KITTITAS COUNTY COMMUNITY DEVELOPMENT SERVICES

Subject: Akehurst (LPF-21-00009) Final Long Plat – Staff Review, Return of Application- Additional Information Required.

Kittitas County Community Development Services (CDS) received your Akehurst (LPF-21-00009) Final Long Plat submittal on August 24, 2021. Kittitas County staff have completed a review of your final plat submittal. As provided below, staff has the following comments, requirements, and/or revisions for your application that need to be addressed prior to final approval and signature of the final plat mylars:

AKEHURST PLAT LP-08-00033
 LEVI VENN
 A PORTION OF THE NW 1/4 OF SECTION 20,
 TOWNSHIP 18 NORTH, RANGE 19 EAST, W.M.,
 KITTITAS COUNTY
 DWN BY _____ DATE _____
 D.L.P./G.W. _____ 08/2021
 JOB NO. _____ 21114
 SHEET _____ 1 OF 2
 SCALE _____ 1" = 200'

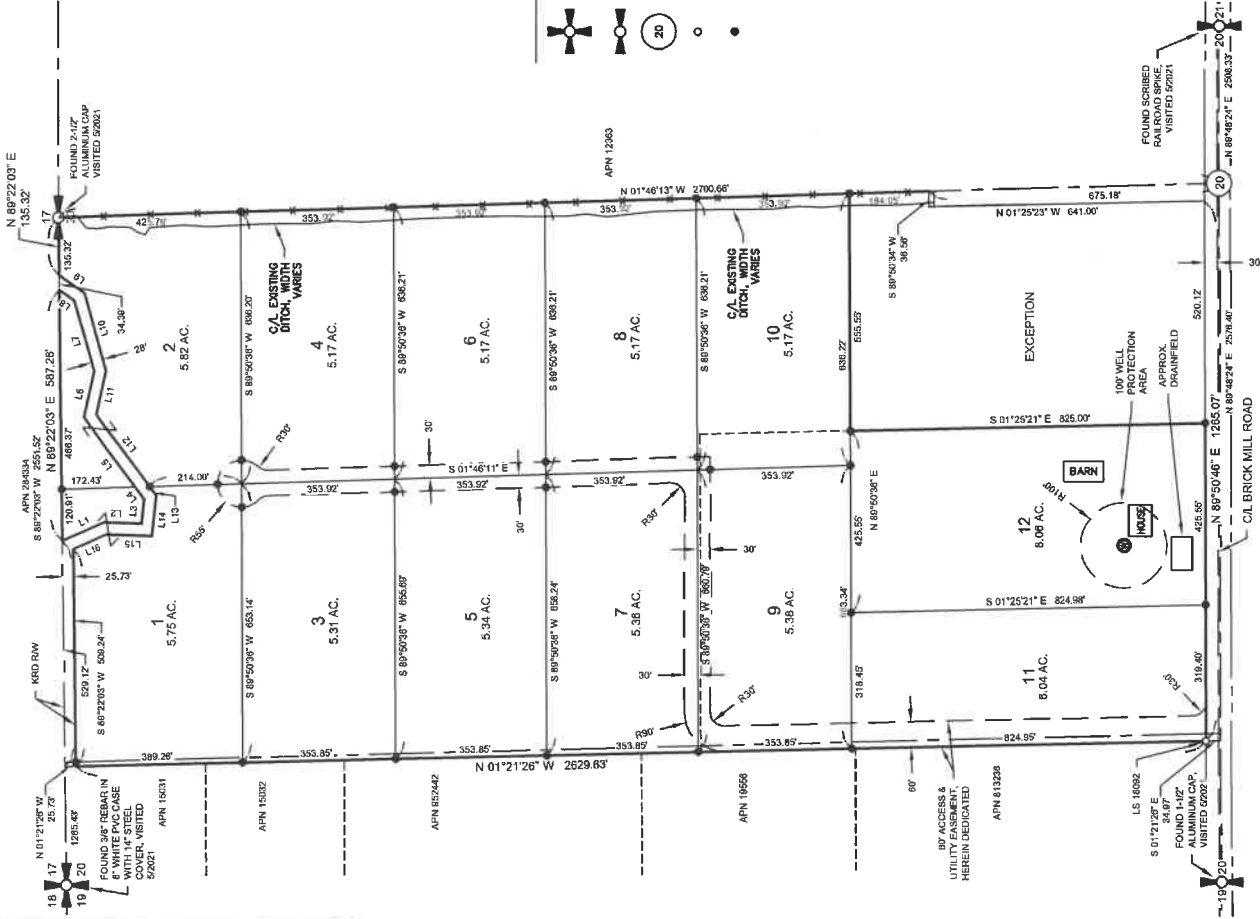
- The final mylars shall note the final plat file number LPF-21-00009 on the face of the plat in addition to the preliminary approval number already noted.
- Taxes on parcel #'s 954945, 954946 and 784434 must be paid in full before final signature.

- Under property information on Sheet 2, the following parcel numbers need to be added: 954945 and 954946 as well as the corresponding map numbers: 18-19-20054-0001 and 18-19-20054-0003 and associated information.
- Parcel #'s 954945 and 954946 should be added to the certificate of the county assessor and certificate of county treasurer as well.
